Subject: FW: "Compulsory Acquisition" RE: Examination Timetable
Attachments: Submission relating to proposed compulsory acquisition 021123.pdf; Submission re BNG considerations - questions for environmental hearing on 091123.pdf

Bramford-Twinstead: Additional Submission to the Planning Inspectorate relating to site specific matter re proposed 'temporary'* access and use of land off A1071 02/11/23
(prepared for Acquisition / Access issue-specific hearing 8th November 2023)

Temporary Access at and around our property entrance (Site Refs: 6-30, 6-31)

Submission relating to Biodiversity Net Gain (“BNG”) / Environmental considerations 02/11/23
(prepared for Environmental hearing 9th November 2023)

NG DRAWING No. BT-NG-020621-545-0007 SHEET NO. 06 NO. OF SHEETS 30 ISSUE: B

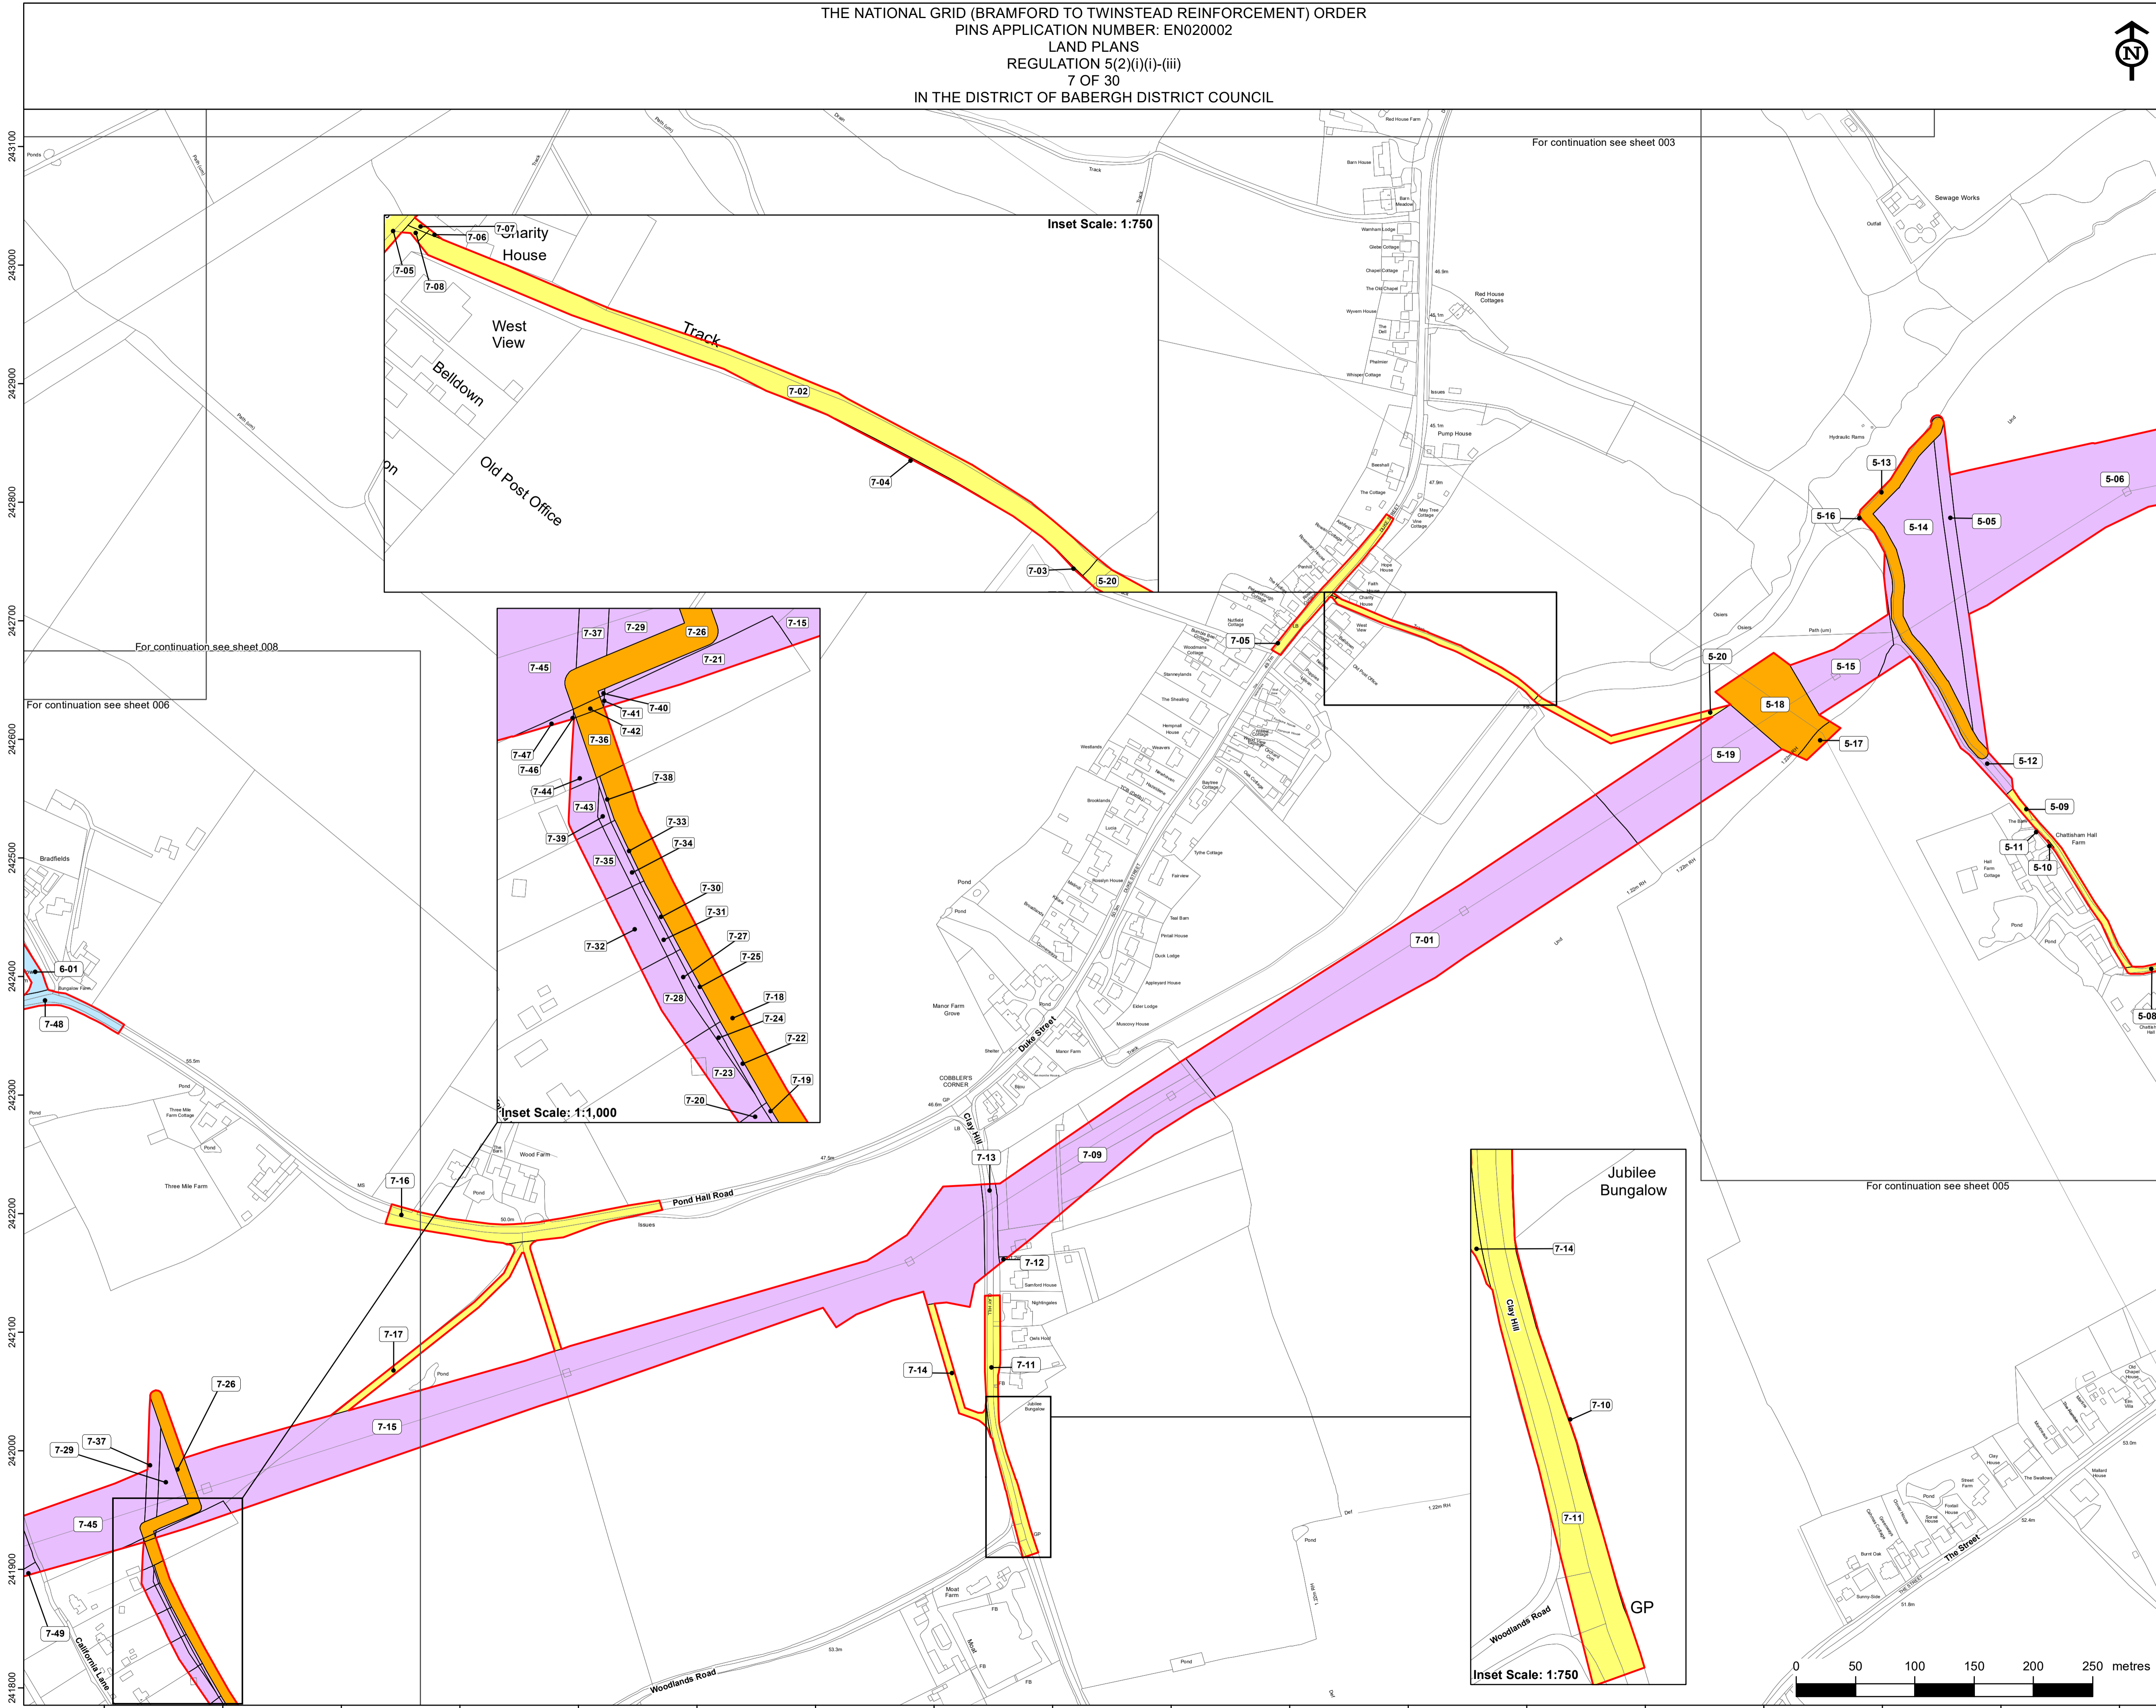
We have specific comments regarding the proposed use of part of our entrance track (plot 6-30), including main road access (plot 6-31), in order to access the scheme, intended here for access (shown as Class 7/0) to proposed "environmental areas" (described to us as areas for "Bio-diversity Net Gain").

- Such access as shown on plans would be completely unnecessary and not be required in order to access any environmental areas at ENV04 in the Application general arrangement plans and also now shown in its updated "Book of Reference" as 6-24 (also with reference to ENV19 / 6-21).

- Additionally, there are better, safer and closer access points e.g. at 6-49 for example, and which would not affect residents (this is our main and only road access to three properties, barns and land) nor unnecessarily run over 300m across arable fields, skirting around the back of a section of ancient woodland (with nesting birds and mammals).

- Even if access rights were granted - we are in discussion with National Grid regarding a possible voluntary agreement - then the area shown (I estimate around 30-40m of track) is unnecessarily large/long:

- The proposed area shown would look to involve removal of a section of an estimated 10-20m of ancient hedgerow and important drainage ditch, which is also an important corridor link between two SSSI sites. This would also be unnecessary.
The current access arrangement to the field is presently used by all types of agricultural equipment and would be more than adequate for the type of activity such an area would require.

- I also note that in addition to unnecessarily removing 1800sqm, the proposed new access route (6-32) would leave a strip of farmed land between it and the wood/hedge, presumably making that un-usable – unnecessarily taking out a further 1500 sq m (est.).

- Consequently, without 6-21, access 6-29 would not be required. (Together both would unnecessarily reduce arable land by 3400 sqm).
- All of this is excessive. It is not, as National Grid states in its documents, the "minimum land necessary" (at best it is hedging for some so far undefined activity across a very large area – see comments below – and with reference to "biodiversity net gain" requirements).

- 5 **The plans seem to have further changed** - or allowed scope to do so - since the start of the Examination – with the addition of the blanket phrases:
 "The Land Plans have been updated at Deadline 1 to reflect the fact that Class 5 rights (Compulsory acquisition of rights for biodiversity net gain) are no longer sought in respect of certain plots.
 "Equivalent changes have also been made to the Book of Reference."

These Application documents (2.3 (B) now feature the removal of the annotation "ENV" and the colouring of all previous such land the same (green), and now as green, for "Class 2 - compulsory acquisition of rights – Overhead line".

- We would ask the Planning Inspectorate to consider this use of our access track and road entrance as unnecessary, with needless take-over of land and creation of additional and long-term disruption to people (and their access to homes) and to wildlife;
- we would also draw attention to the related changes that have been made since consultation and without proper discussion or agreement, as detailed below:
